EGP19005-R2b-GEC-Redlines Summary_Markup Summary

BENT GRASS RESIDENTIAL
EA 18-203
SF 19-014 / EGP-19-005

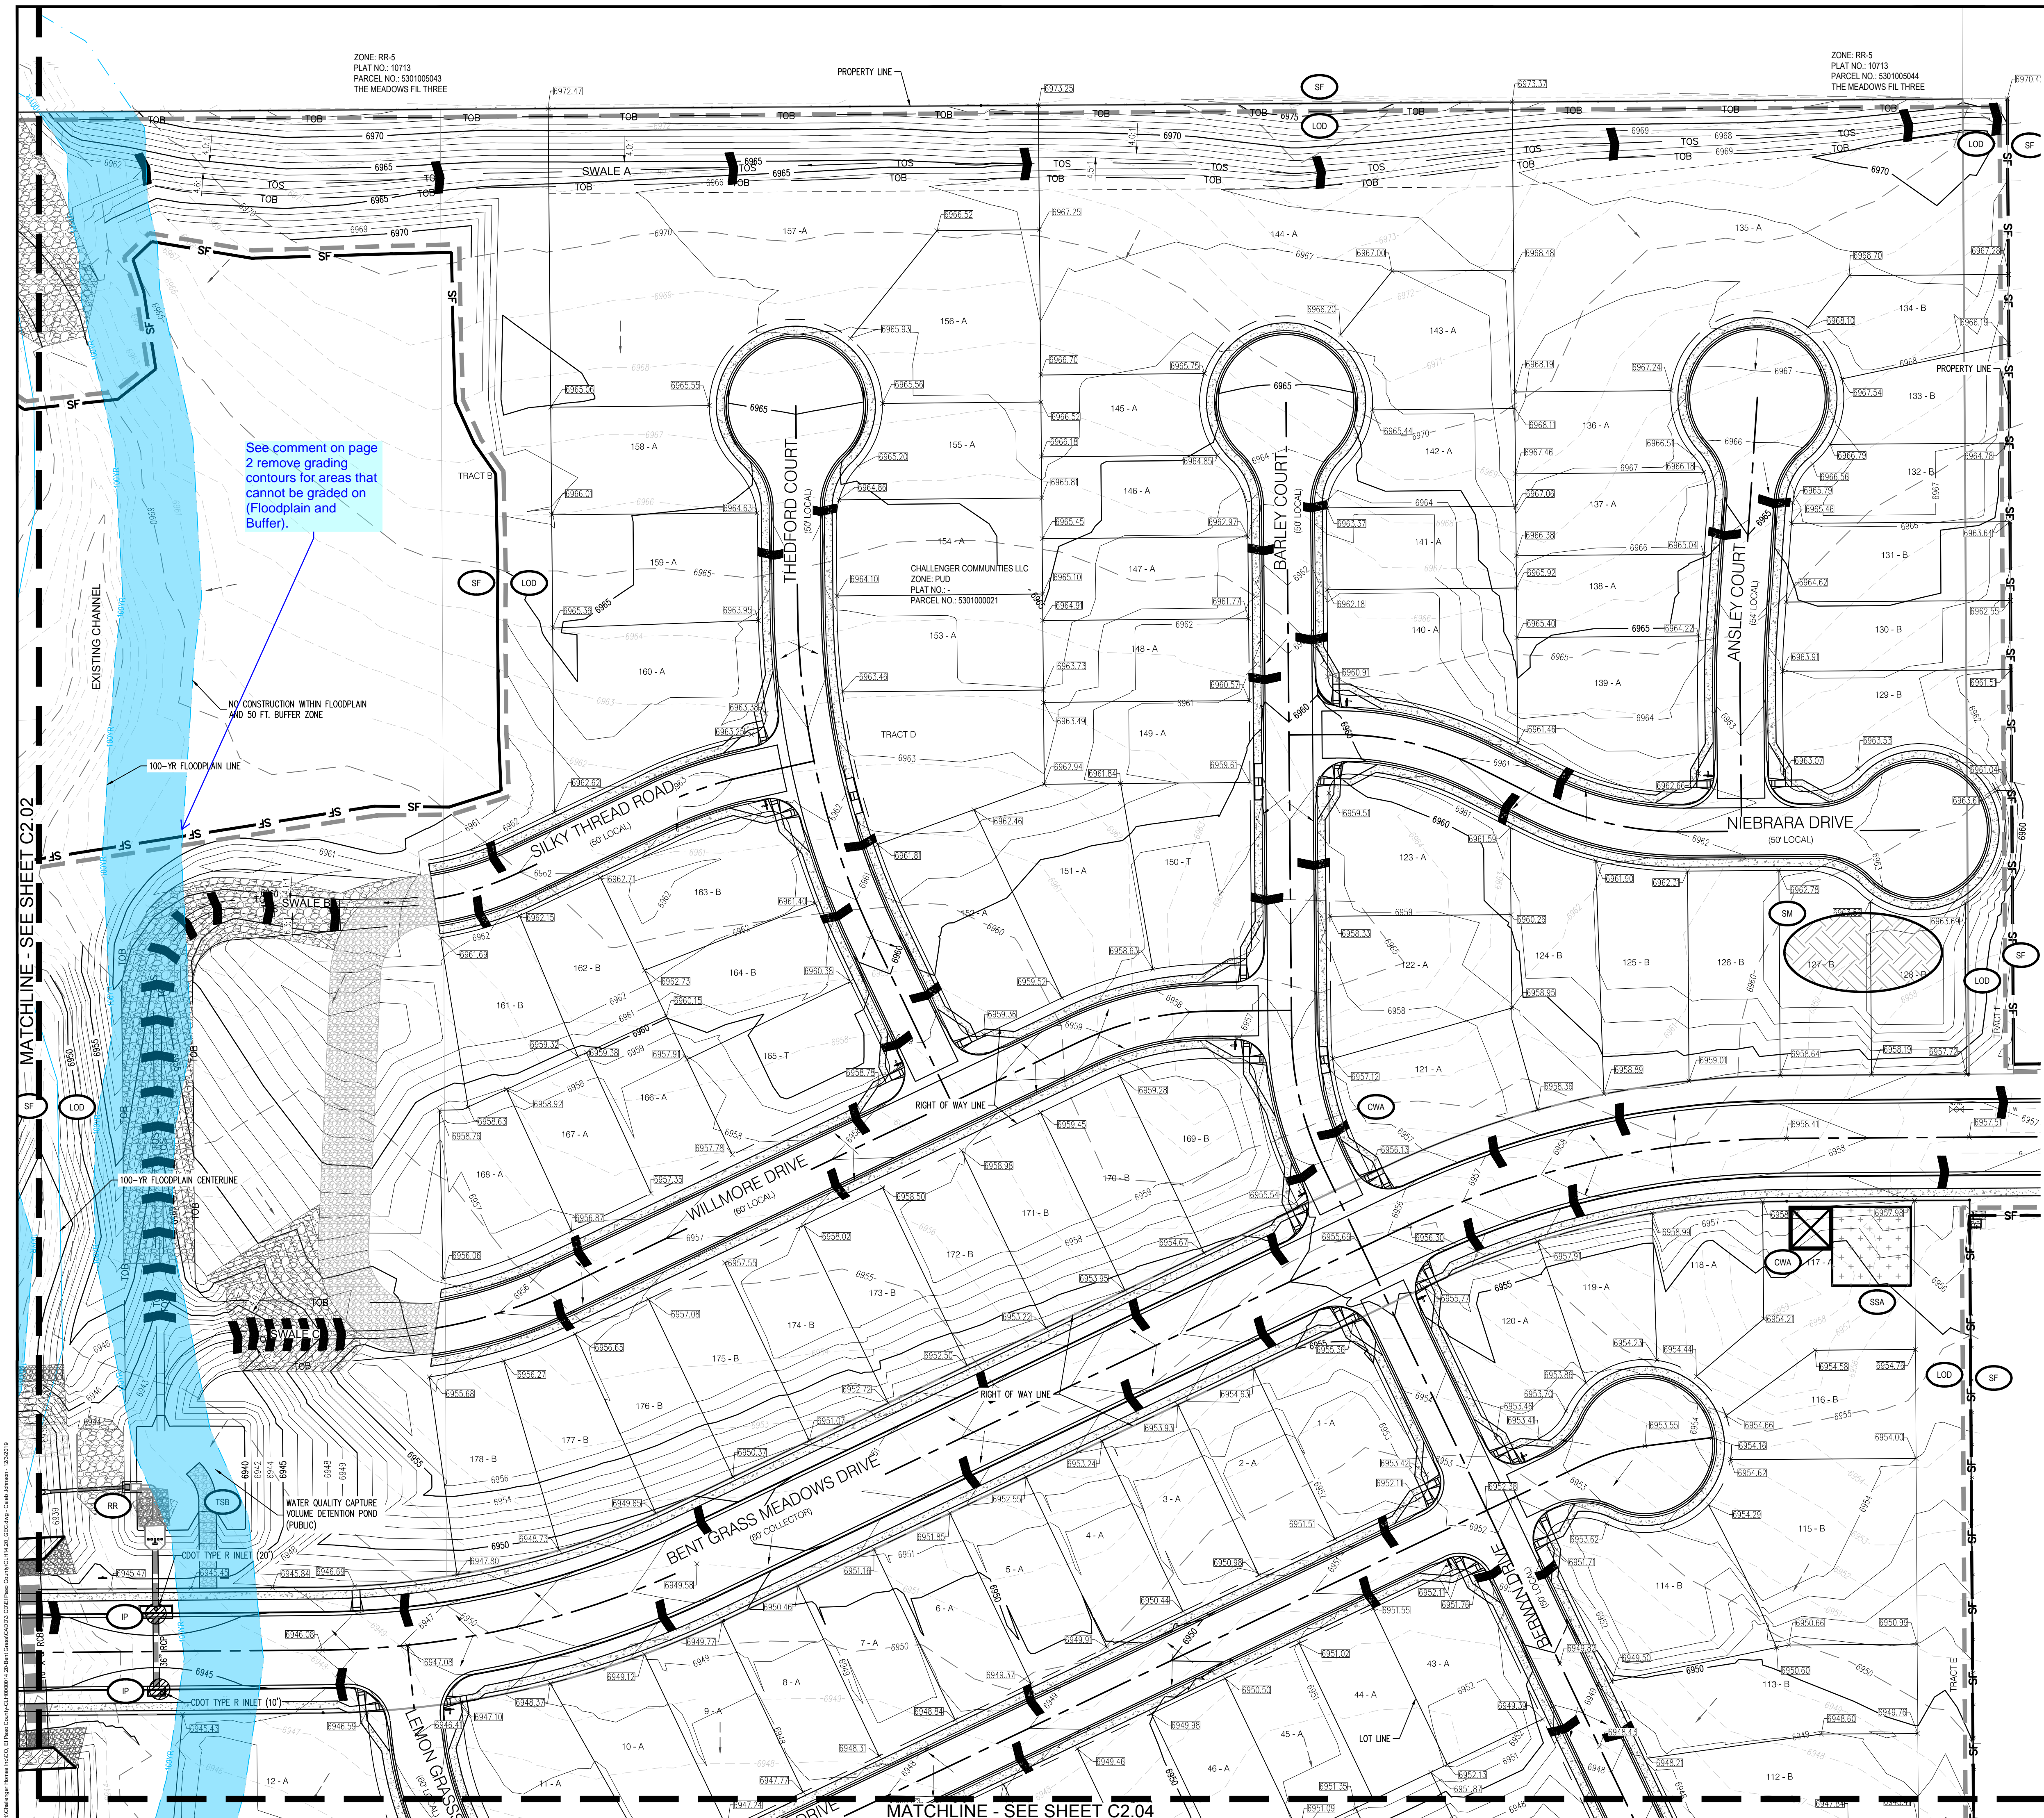
Area to be protected by Construction safety fence

Revise / delete the silt fence

INTERIM GRADING & EROSION CONTROL PLAN

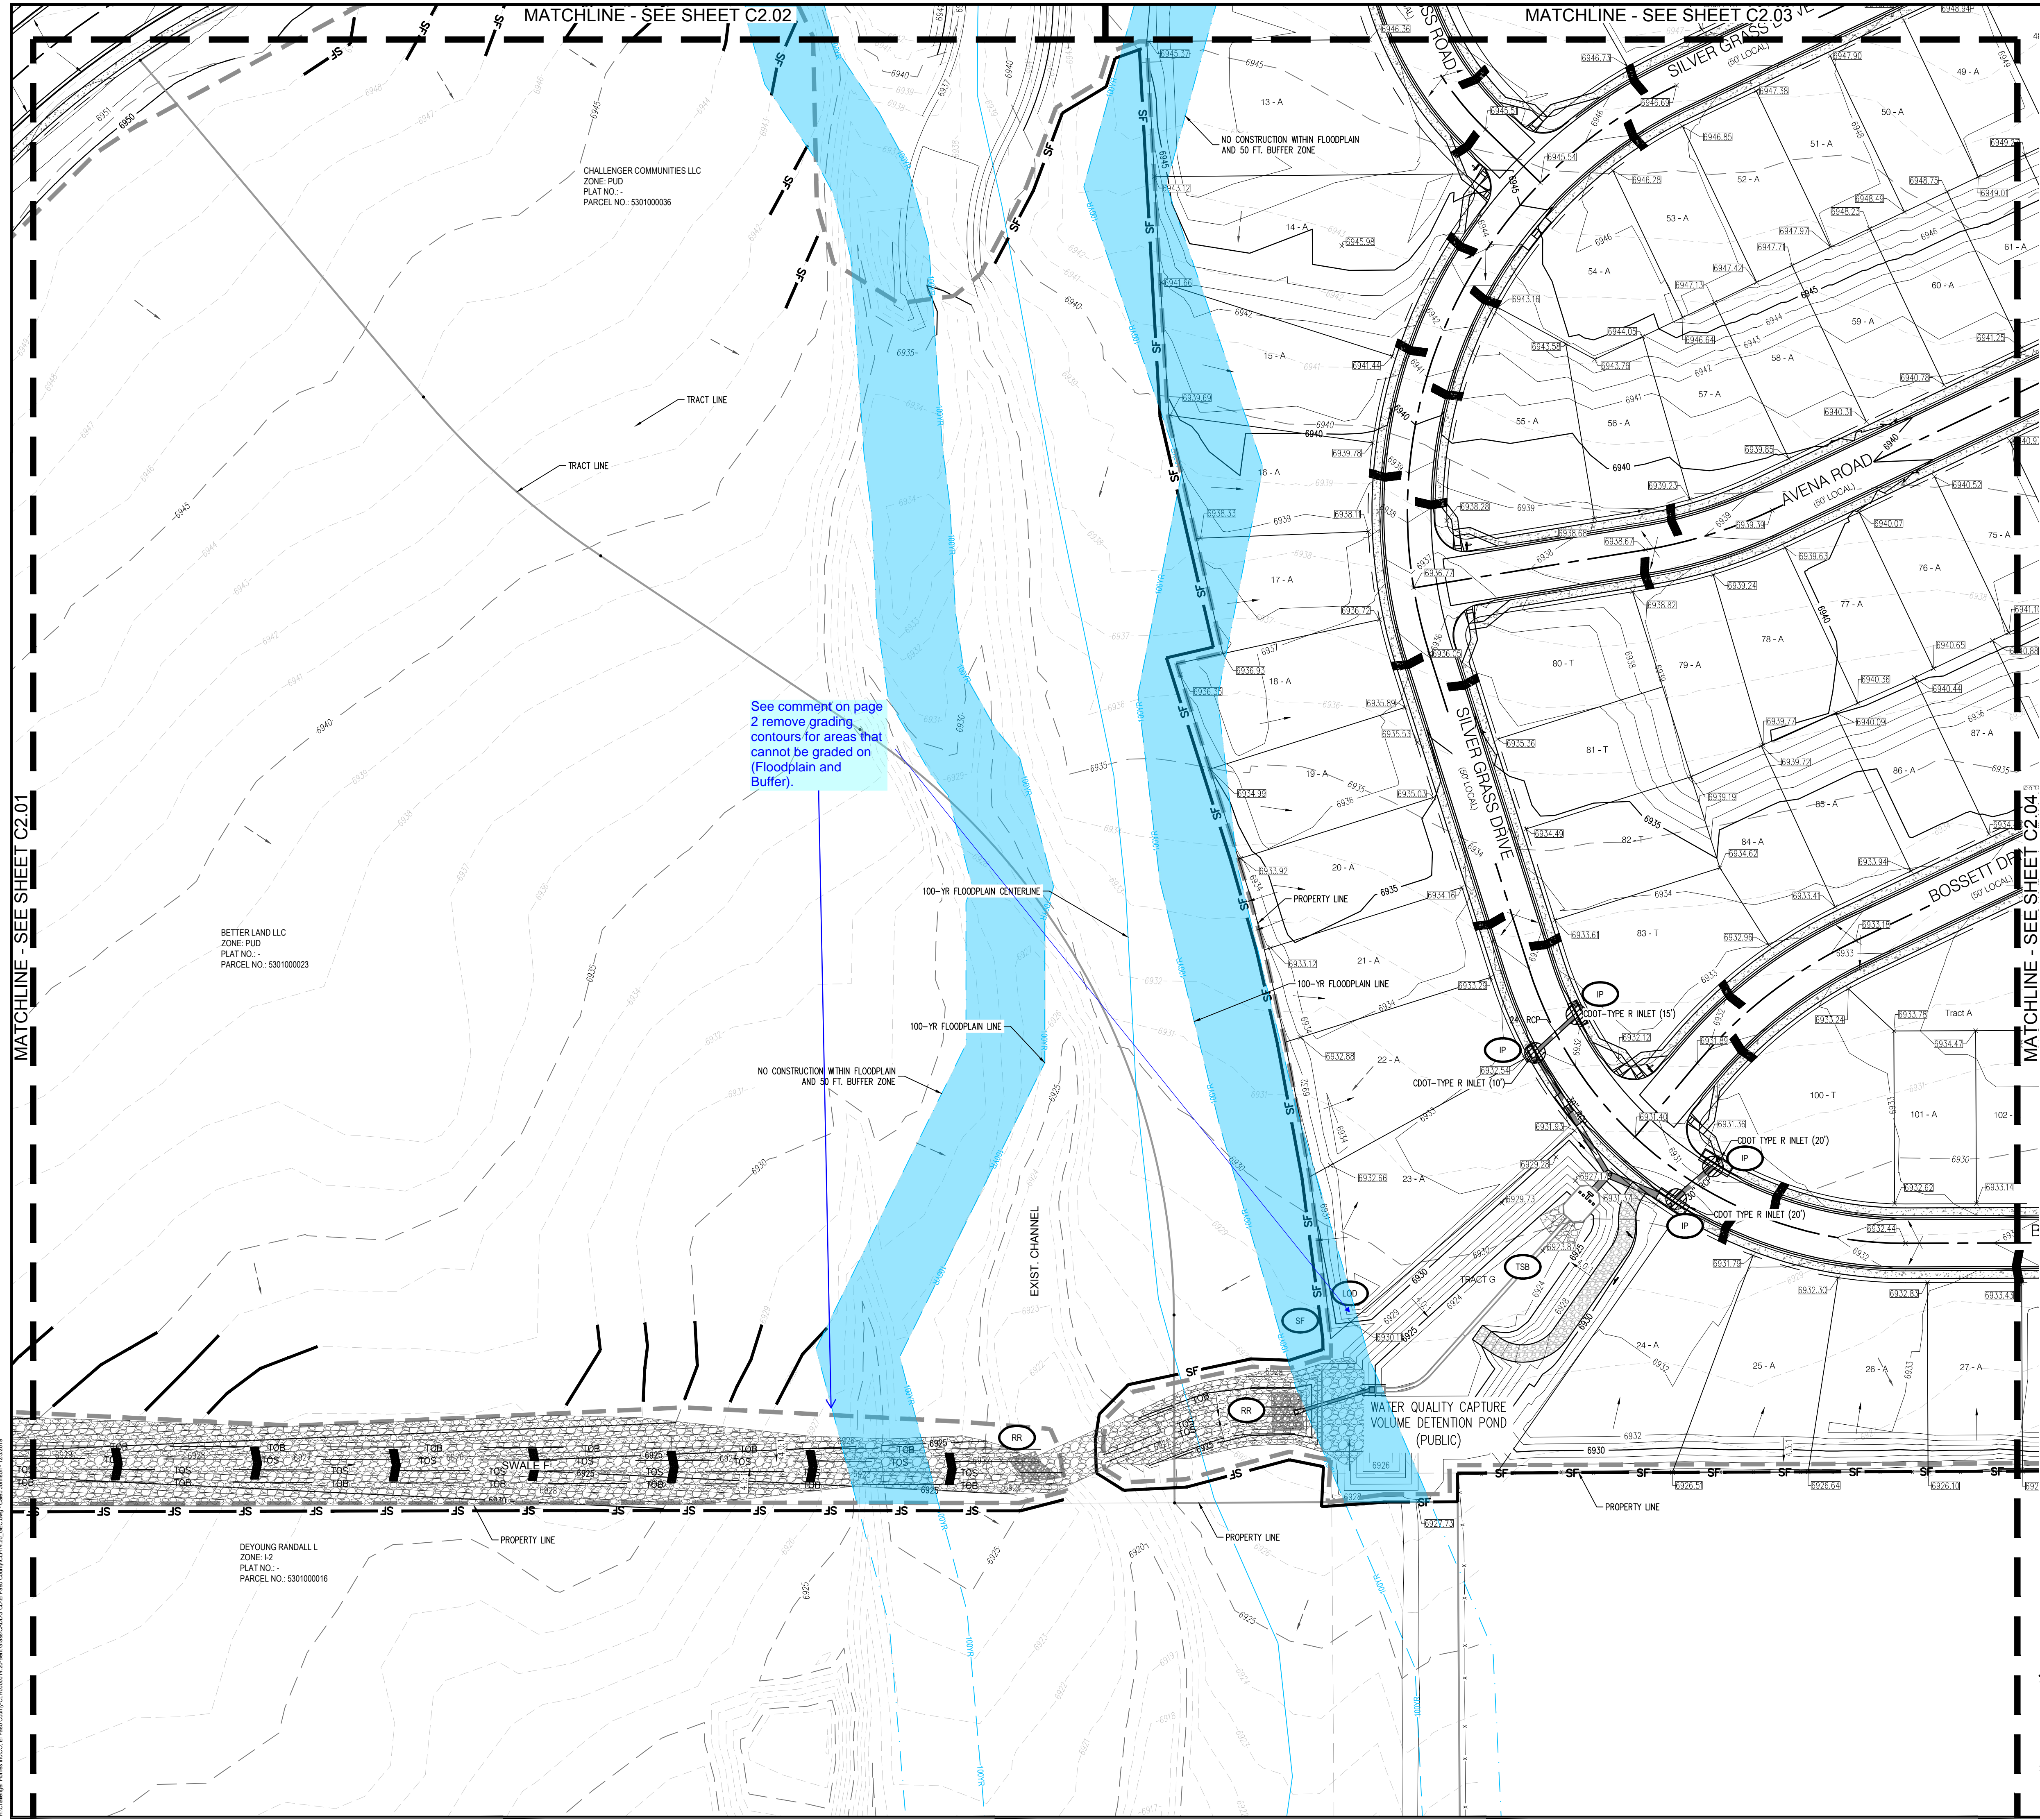
Area to be protected with Construction Safety Fence.

Provide a detail to show 3:1 slopes from the floodplain buffer zone up to where construction grading may start.

Call out slopes (slopes greater than 3:1 require erosion blankets) Comment typical for all slopes on this plan.

Include a "Limits of disturbance" symbol & line for the Floodplain buffer area.

Remove grading contours and improvements for areas that are not going to receive construction.

If there is no work in the channel, revise the grades from the swale and new channel to tie in outside of the channel or remove from this GEC plan
